6/2018/3255/FULL

Plot 5610, Gypsy Moth Avenue, Hatfield Business Park, Hatfield, AL10 9BS

Erection of a pre-delivery inspection facility (Use Class B8), together with car storage area, staff car parking, cycle parking, boundary treatment, landscaping, lighting and access

**EXTERNAL LIGHTING LAYOUT**

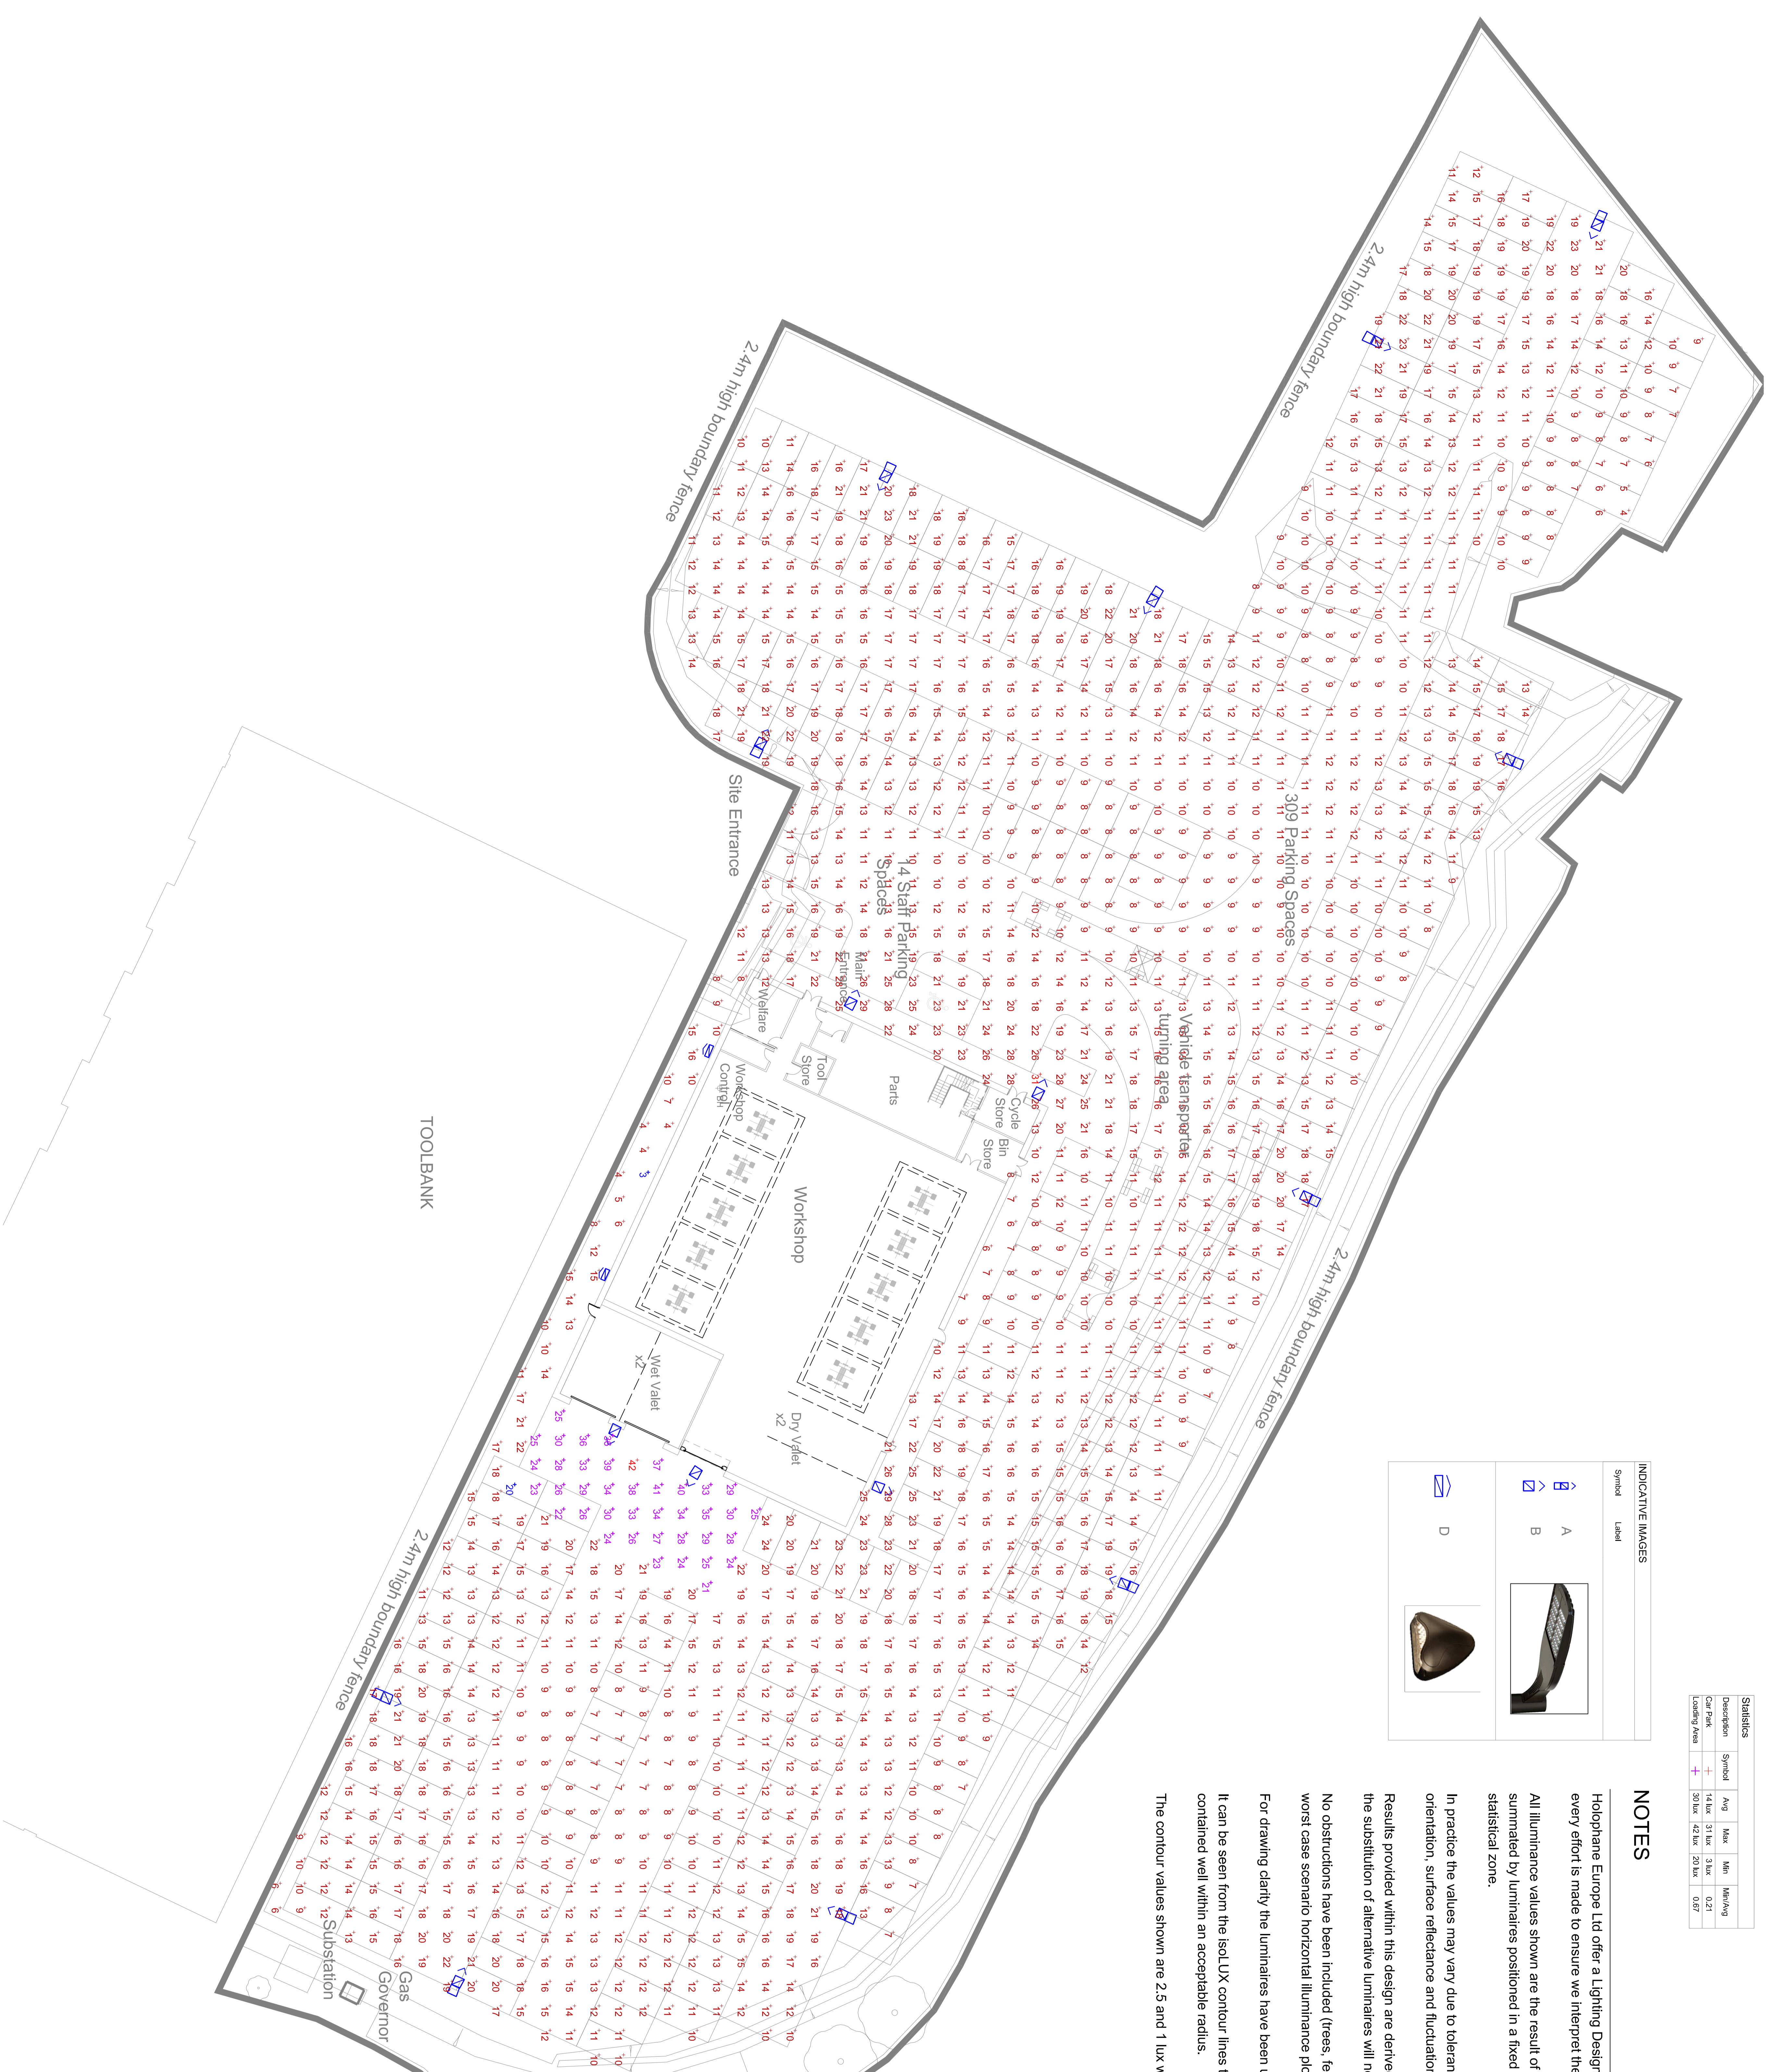
It would be appreciated if delivery trucks did not use Hatfield Avenue in the same way that PCL/Arla are restricted by their planning conditions. Assuming that this is a pre-delivery inspection facility only, this would not require high-powered vehicles to be revved creating noise as part of those inspections? It would also be assumed that these high-powered vehicles would be driven from the inspection facility to the dealership quietly and calmly within the 30mph speed limit (bearing in mind this is a pedestrian route from the Garden Village to Howe Dell School). The landscaping plan facing the Garden Village looks a bit sparse and a more ambitious planting plan matching the PCL/Arla side would dramatically lessen the visual impact of the facility to the benefit of the surrounding residential neighbours. Please also take care to point flood-lighting DOWN and NOT AT the residences opposite. Many thanks.
